**WEST SUSSEX COUNTY COUNCIL
FLOOD RISK MANAGEMENT CONSULTATION**

SUBJECT: A/99/17/OUT

LOCATION: Land South of, Water Lane, Angmering

Flood risk map

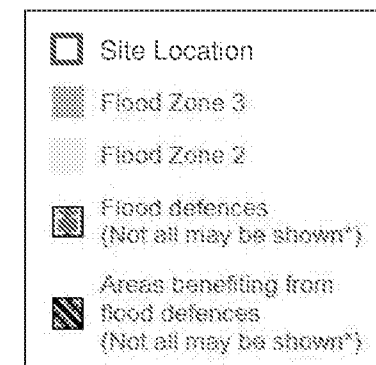
Current surface water flood risk based on uFMfSW:	Moderate risk
Comments: Current uFMfSW mapping shows the majority of the site is at a low risk from surface water flooding but there is high risk in the north of the site associated with the Black Ditch. Any existing surface water flow paths across the site must be maintained. Reason: NPPF paragraph 103 states – ‘When determining planning applications, local planning authorities should ensure flood risk is not increased elsewhere..’ Therefore, a wholesale site level rise via the spreading of excavated material should be avoided. Any excavated material kept on site should be located in areas designed and designated for that purpose.

Records of any ordinary/culverted watercourses within or in close vicinity to the site:	Yes
Comments: Current Ordnance Survey mapping shows no ordinary watercourses within the site boundary although the Black Ditch (main river) runs through the north of the site. Local or field boundary ditches, not shown on Ordnance Survey mapping, may exist around the site. If present these should be maintained and highlighted on future plans. No development should take place within 5m of any ordinary watercourse and access of future maintenance must be considered during planning. If works are undertaken within, under, over or up to an Ordinary Watercourse, even if this is temporary, an Ordinary Watercourse Consent (OWC) may need to be applied for from the District or Borough Council.

The FRA included with this application states that, a combination of infiltration and attenuation techniques would be used with attenuated discharge to the Black Ditch for the northern parcel. This discharge would require EA consent.

Approved Document Part H of the Building Regulations 2000 establishes a hierarchy for surface water disposal, which encourages a SuDs approach beginning with infiltration whenever possible e.g. soakaways, permeable paving or infiltration trenches. Infiltration techniques should be fully explored for the whole site.

Development should not commence until finalised detailed surface water drainage designs and calculations for the site, based on sustainable drainage principles, for the development have been submitted to and approved in writing by the Local Planning Authority. The drainage designs should demonstrate that the surface water runoff generated up to and including the 1 in 100 year, plus climate change, critical storm will not exceed the run-off from the current site following the corresponding rainfall event.
